## Ann Machado - Re: New Led price panels at 393 Commercial St - 042-B-001

**From:** Brian Laflamme  
**To:** Ann Machado  
**Date:** 10/15/2014 8:07 AM  
**Subject:** Re: New Led price panels at 393 Commercial St - 042-B-001

Sign Type 8770.1A

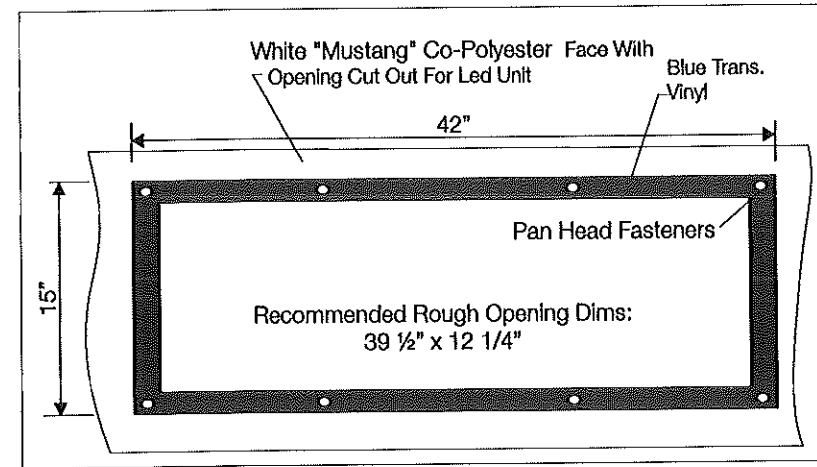
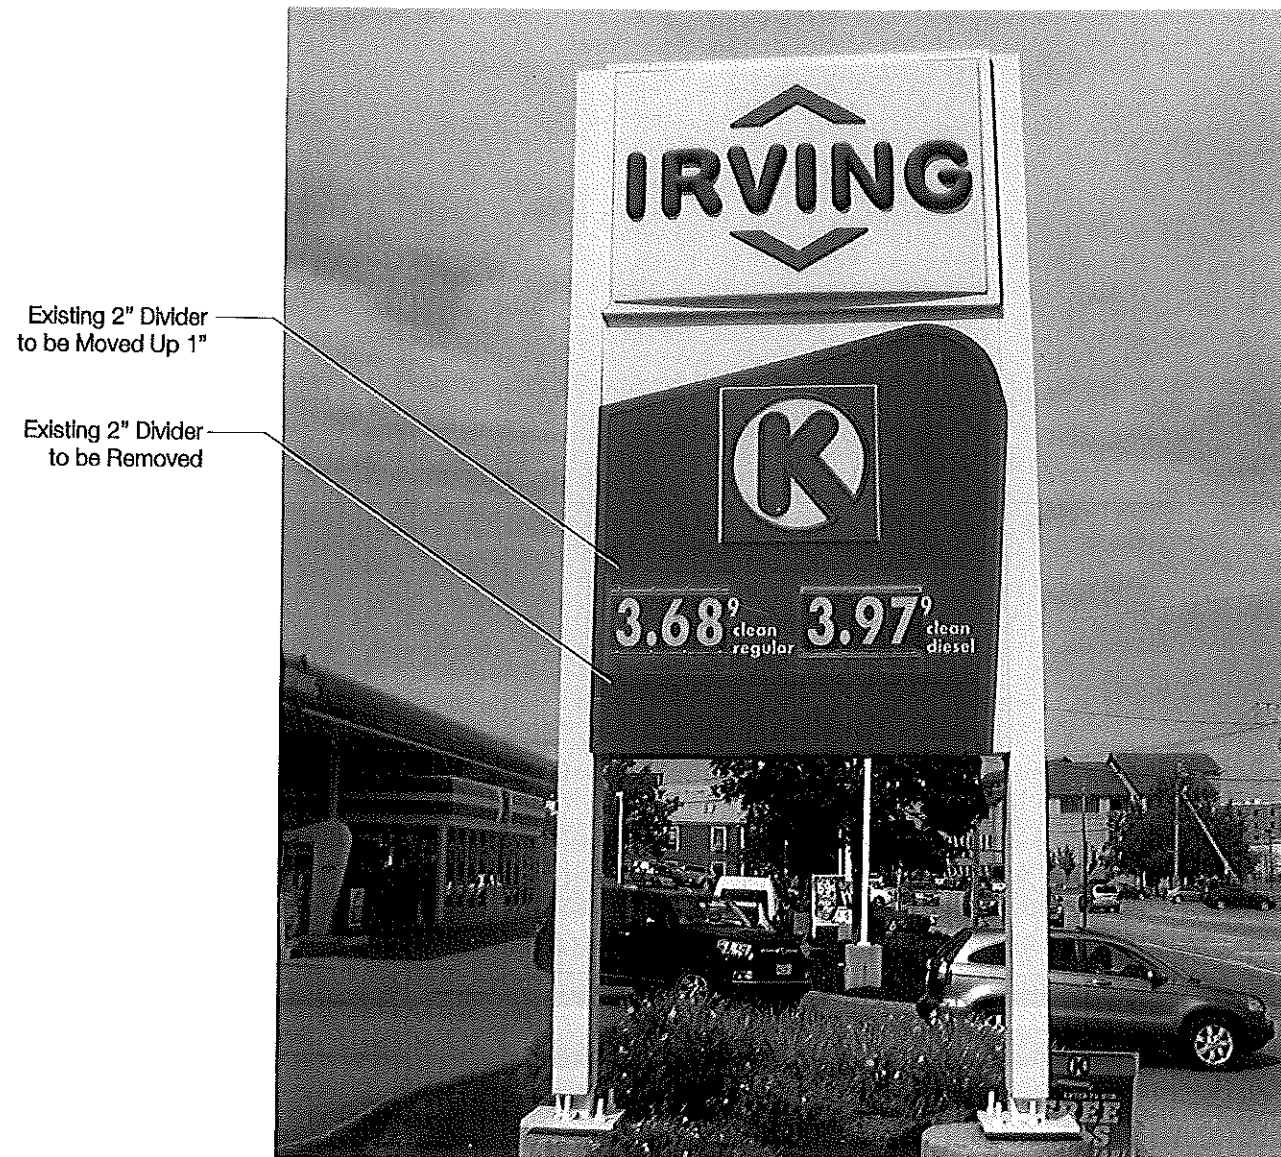
There are no electrical specs or UL listing, this will need to be provided for sign permit.
